From: [REDACTED]
Sent: 25 February 2019 15:55
To: Simon Davis <Simon.Davis@arun.gov.uk>
Subject: RE: BR/281/18/PL 99 Victoria Drive, redevelopment with flats

From: Simon Davis <Simon.Davis@arun.gov.uk>
Sent: 18 February 2019 14:37
To: 'tim@rodwayplanning.co.uk' <tim@rodwayplanning.co.uk>
Subject: BR/281/18/PL 99 Victoria Drive, redevelopment with flats

The Group Head of Planning has declined to sign off the report for the Committee. He has a number of concerns:

PROPOSED GROUND FLOOR PLAN

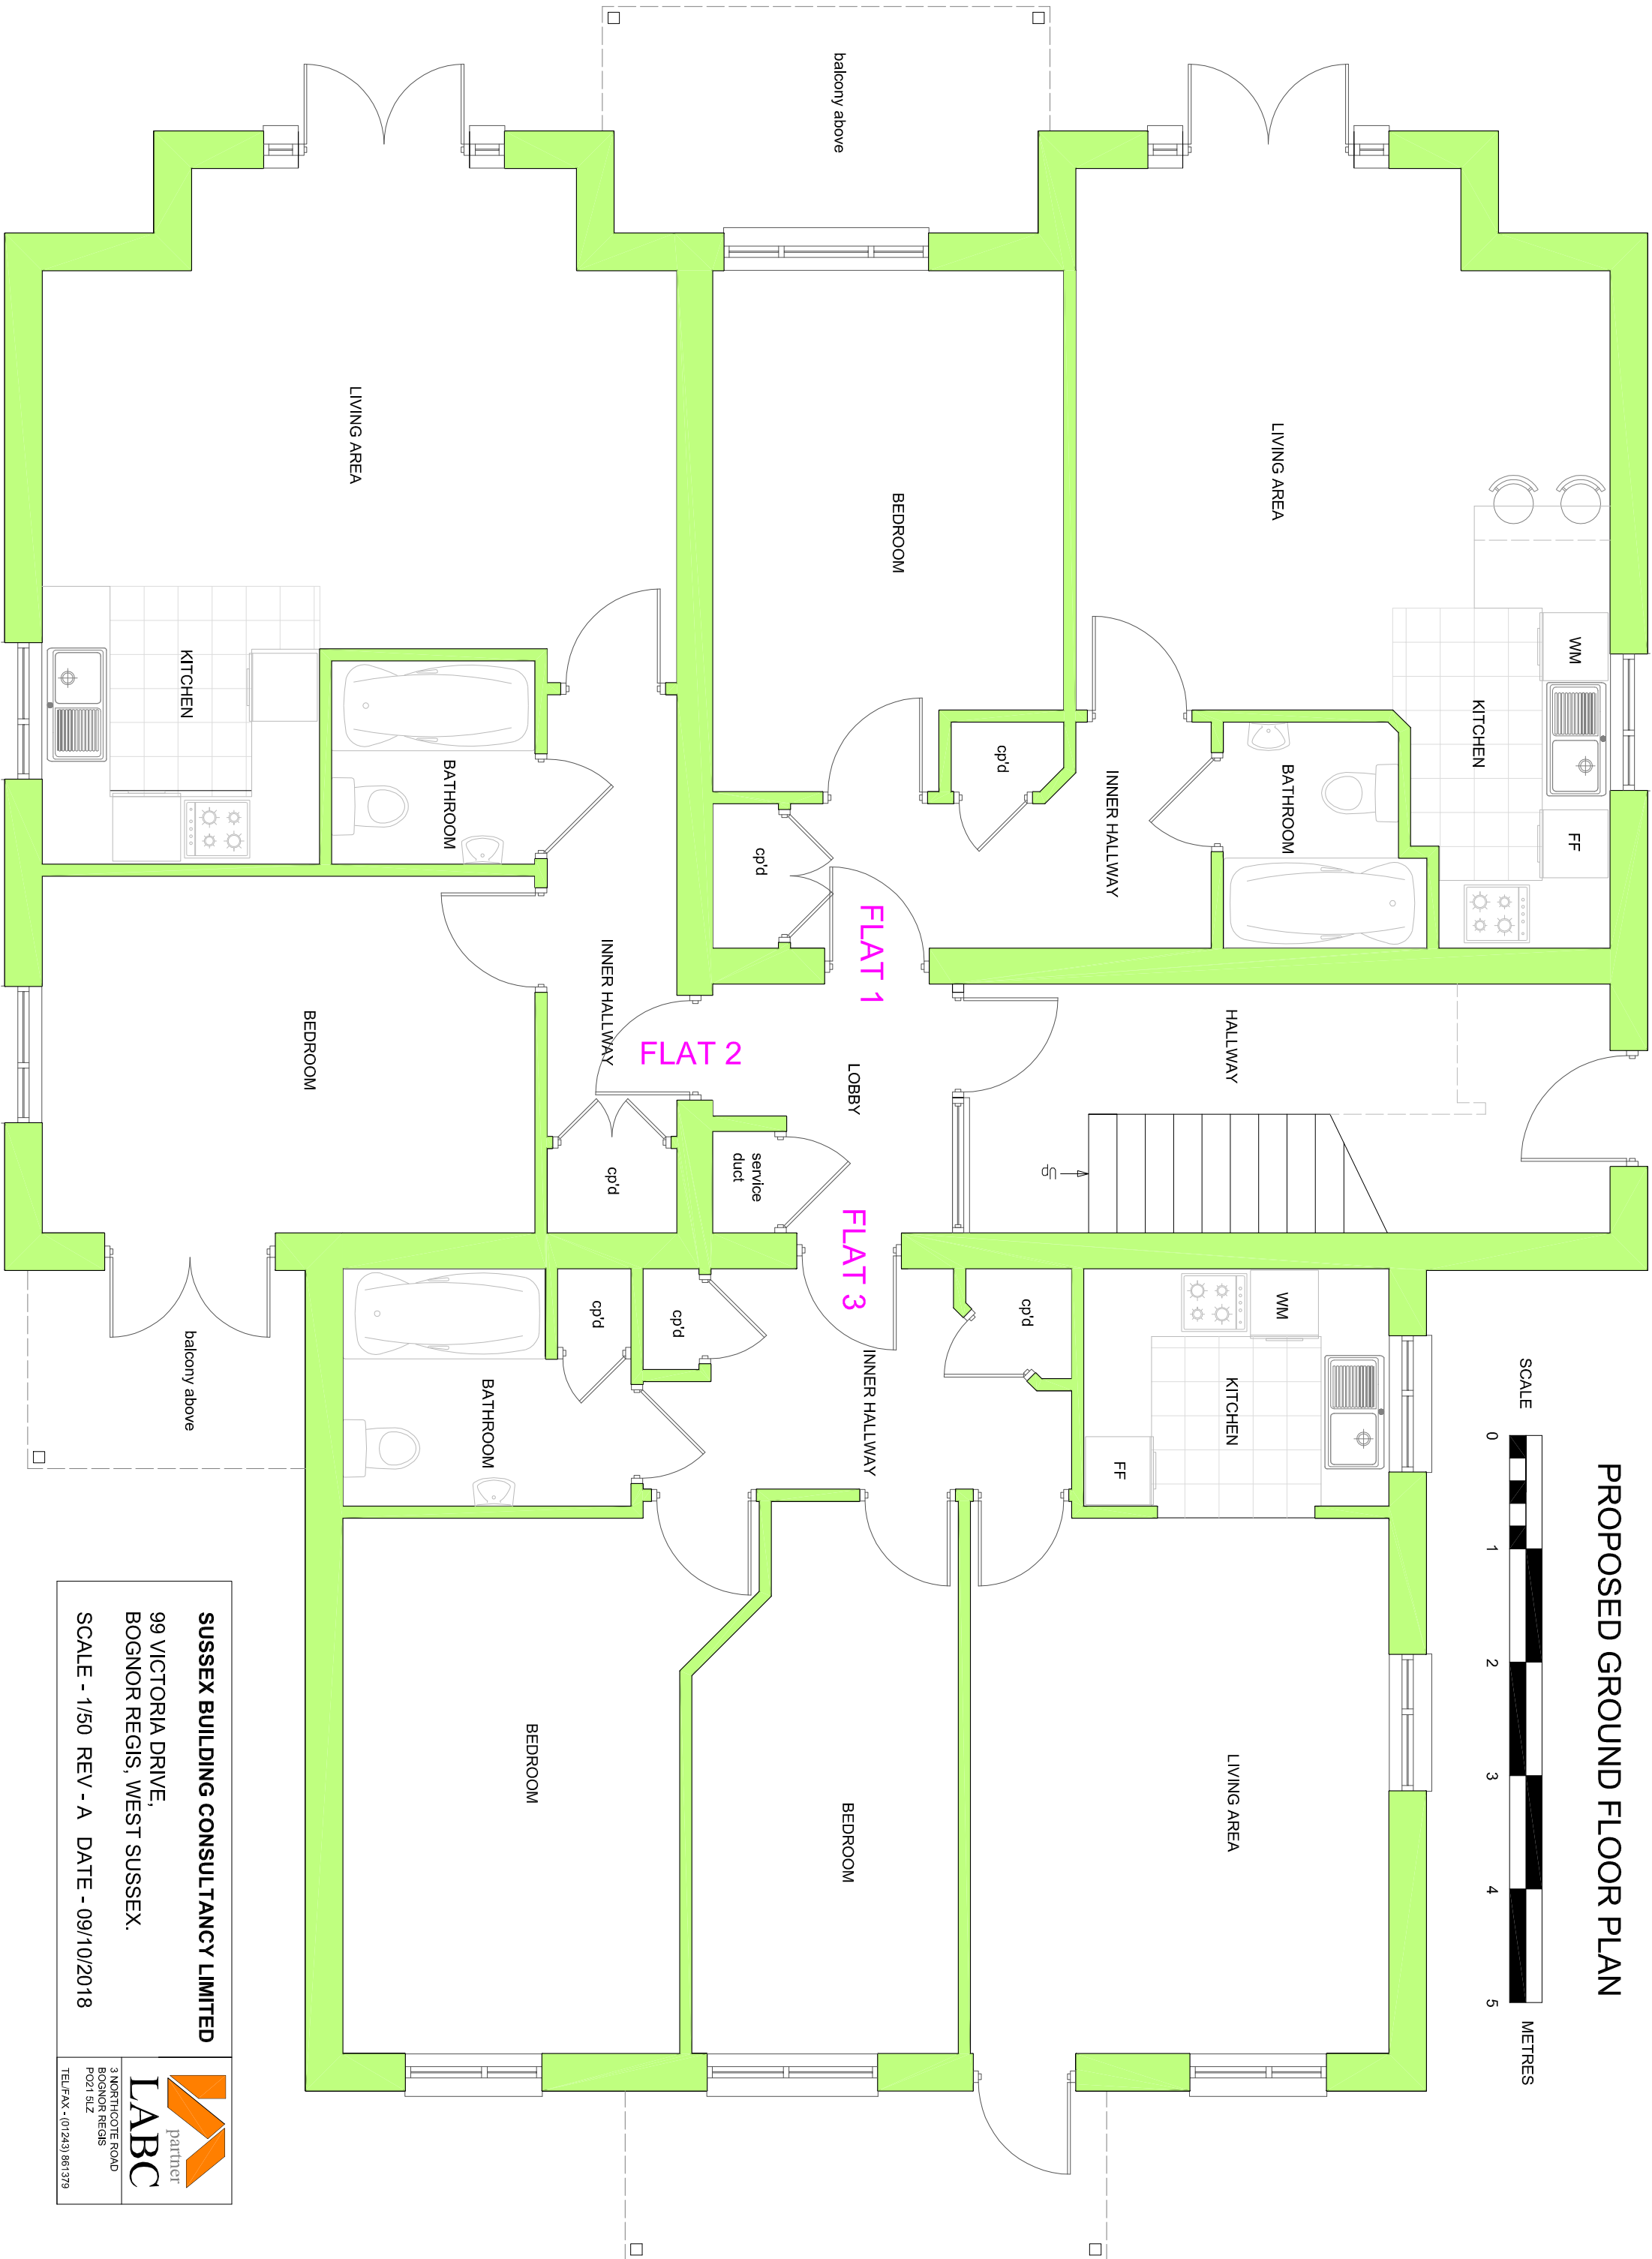
- The parking to the rear and the vehicle movements to the side of a single residential property;
- No other examples of this in streetscene;
- The noise issue is far too quickly dismissed in the report and needs to be addressed – this isn't about a statutory noise nuisance or about noise impact assessments; this is about a change in character and disturbance from moving vehicles and car doors to the rear of residential properties. The parking is right next door to the rear of private residential gardens. I do not agree with our conclusions that this will be acceptable;

PROPOSED NORTH EAST ELEVATION

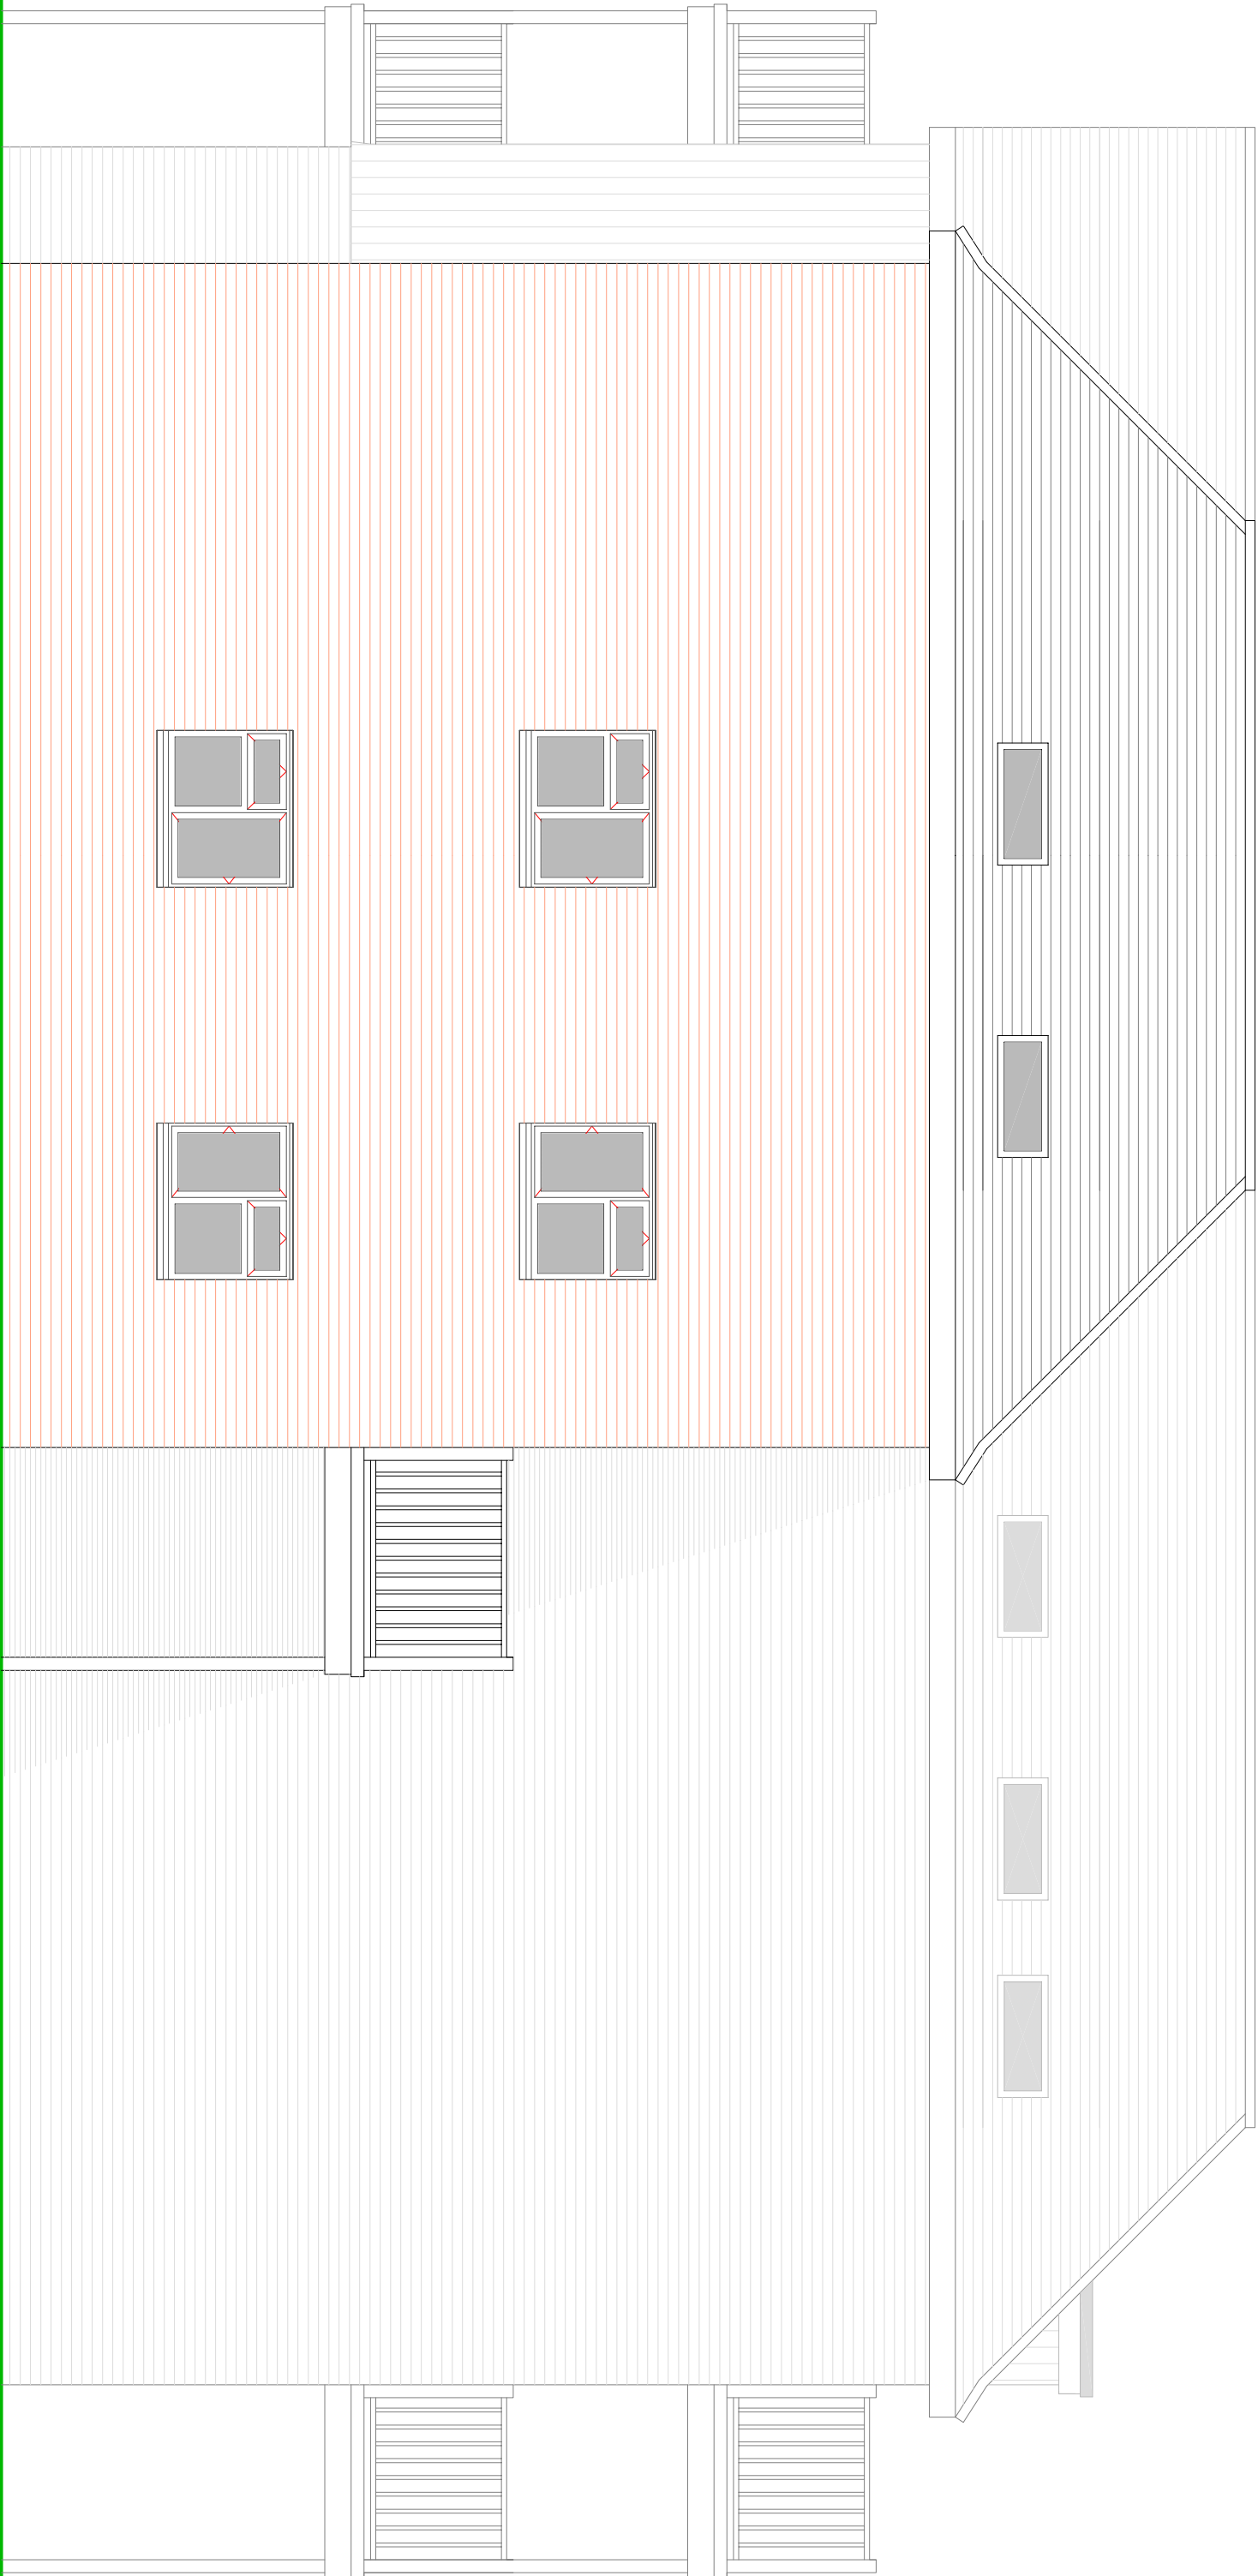
- This proposed building is three stories high and projects 10m to the rear of no.97. I accept the distance separation but put yourself in this garden and think of the scale of that building. That will be over-bearing;

- All windows on the south west elevation of the rear projection need to be removed – not just obscure glazed; and
- I think the above points to the fact that this is too much on too small a site.
